# CITY OF ALBUQUERQUE

January 25, 2016

**RE: Oakland Heights Subdivision (File: C19D063)  
Grading and Drainage Plan, Engineer's Date 12-1-15**

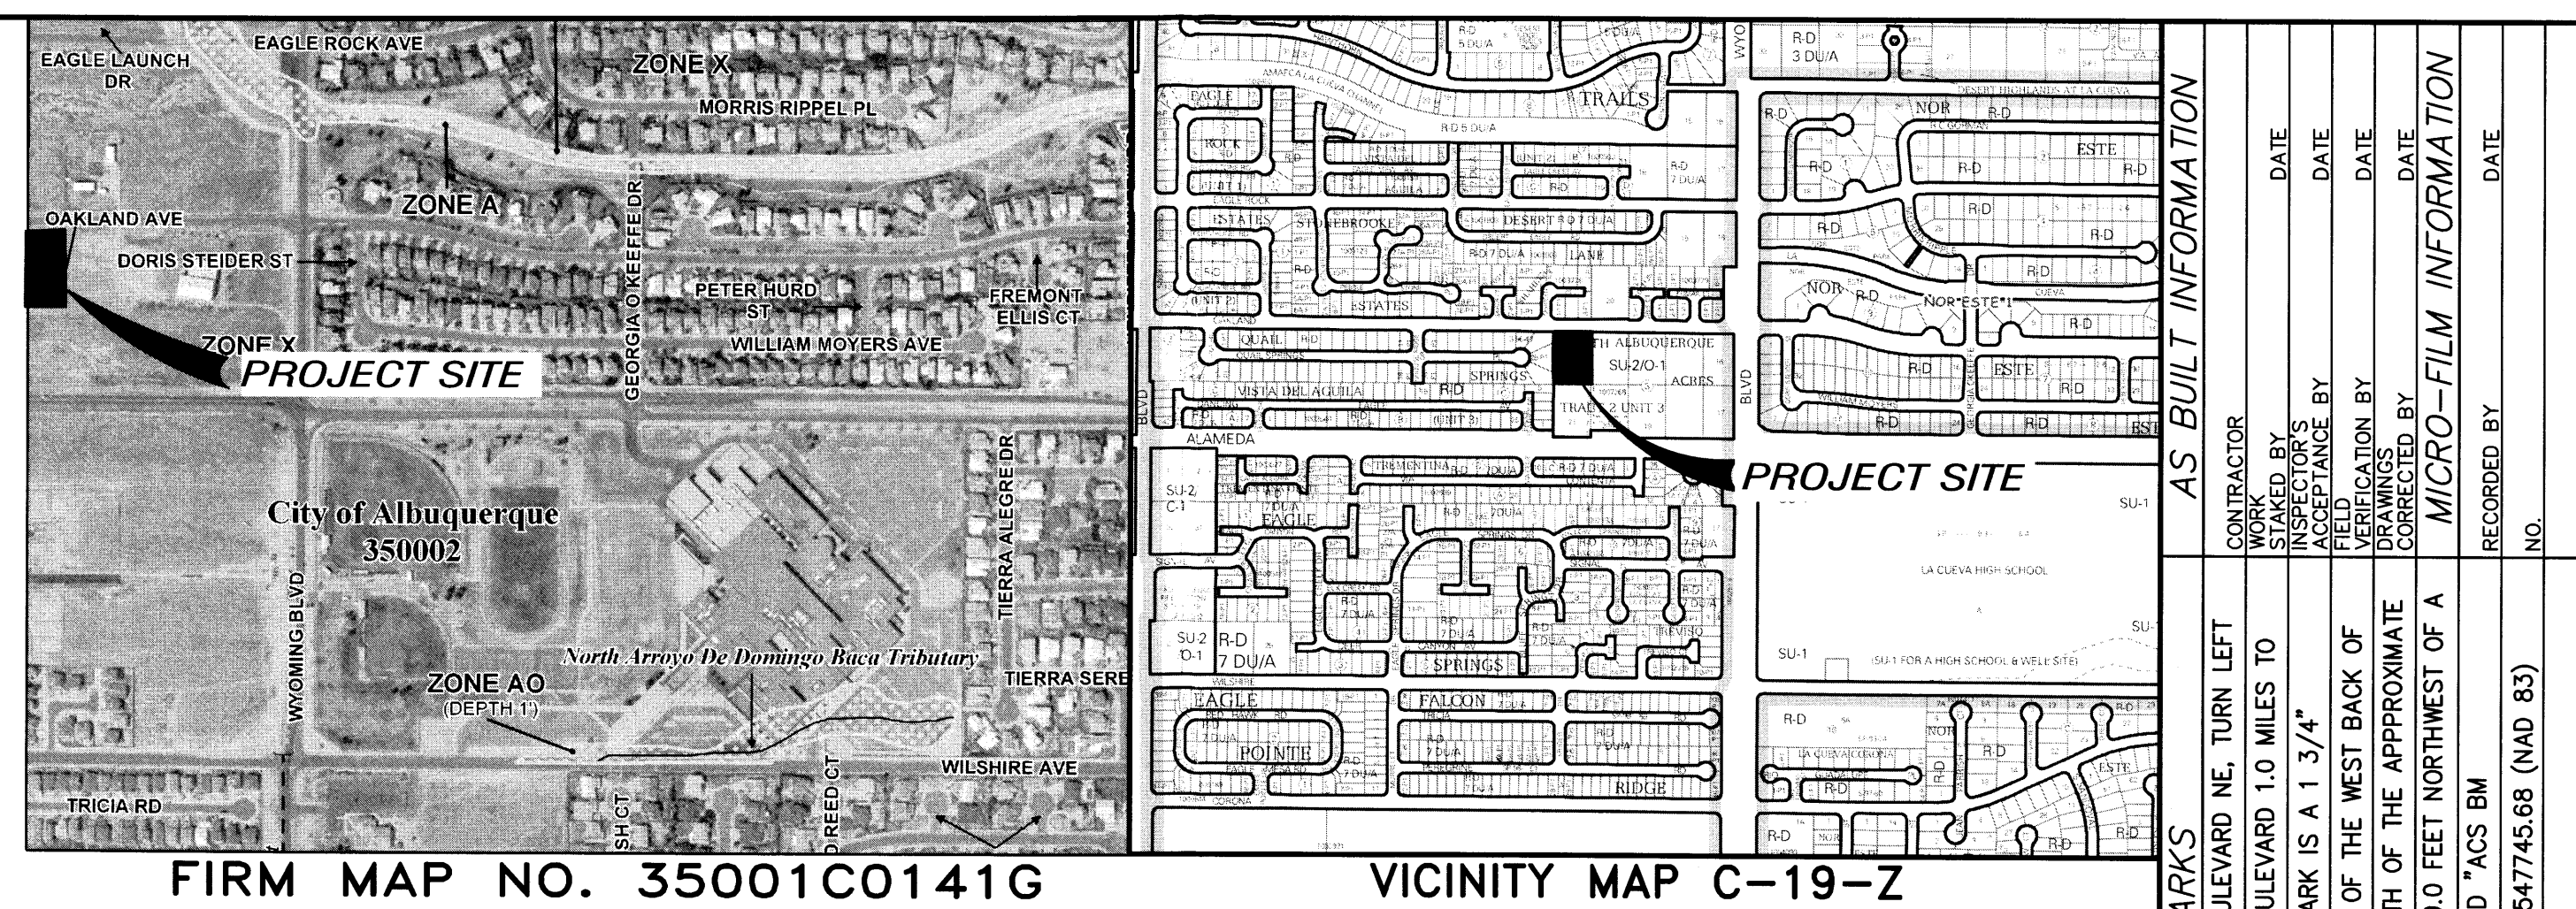
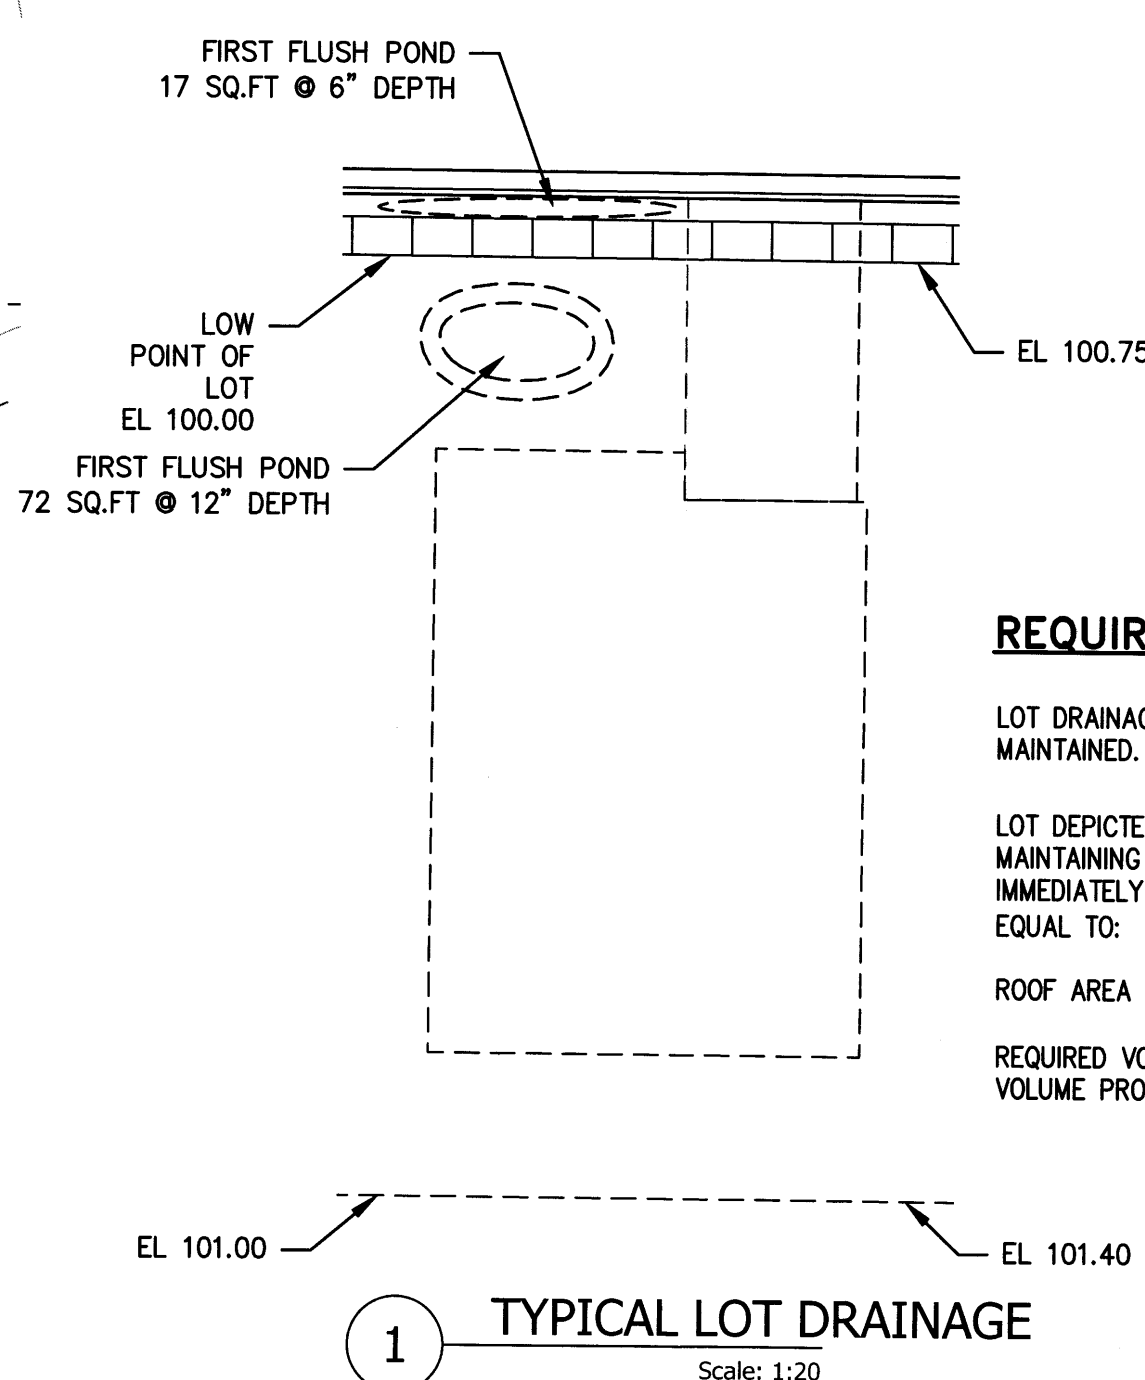
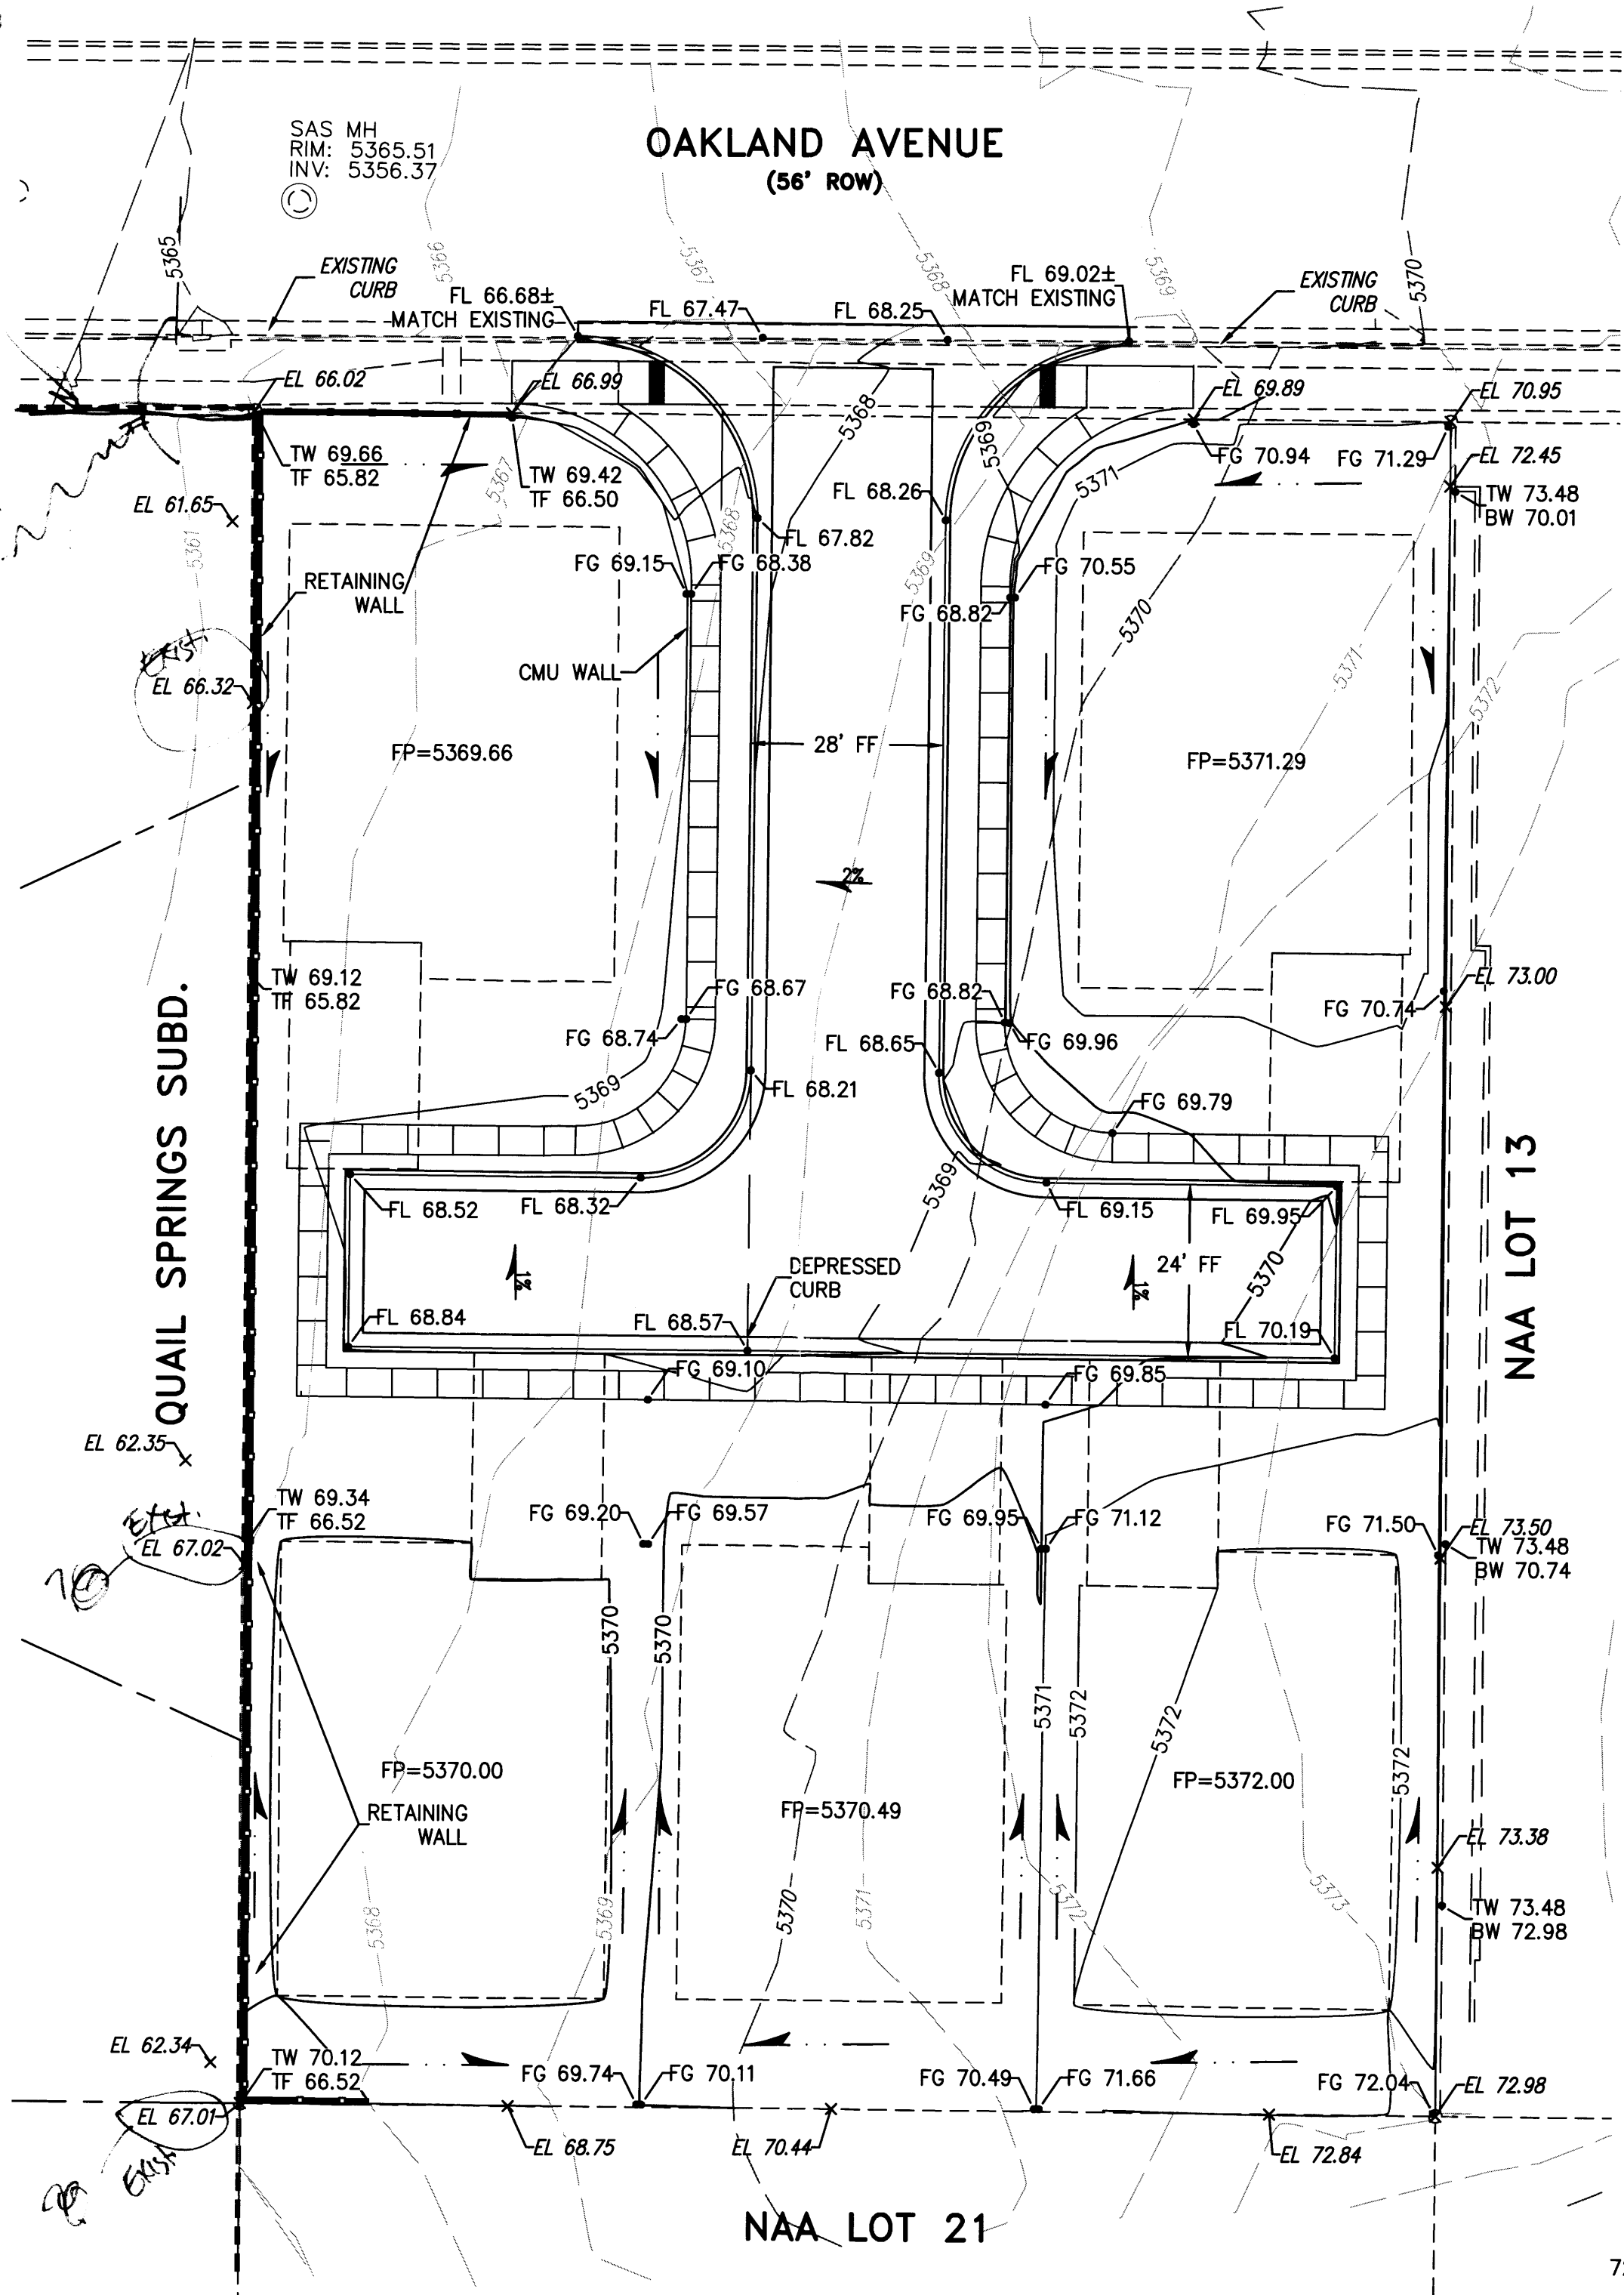
1. Looking at the NAAMDP Appendix, the Land treatments for this sub-basin are 25%B, 15% C, and 50% D (not 60% D as implied in the Land Treatment , Fig. 2A). Revise the Table to reflect these numbers, also state the Basin # that this site is in.
2. Provide existing contours or existing spot elevations for the site west of this development.
3. The East property line will have an existing retaining wall at the time of construction. Show the TW/BW elevations and indicate that it is a retaining wall currently under construction per drainage report C19D062.
4. Indicate in the Narrative why this site does not accept offsite flows.
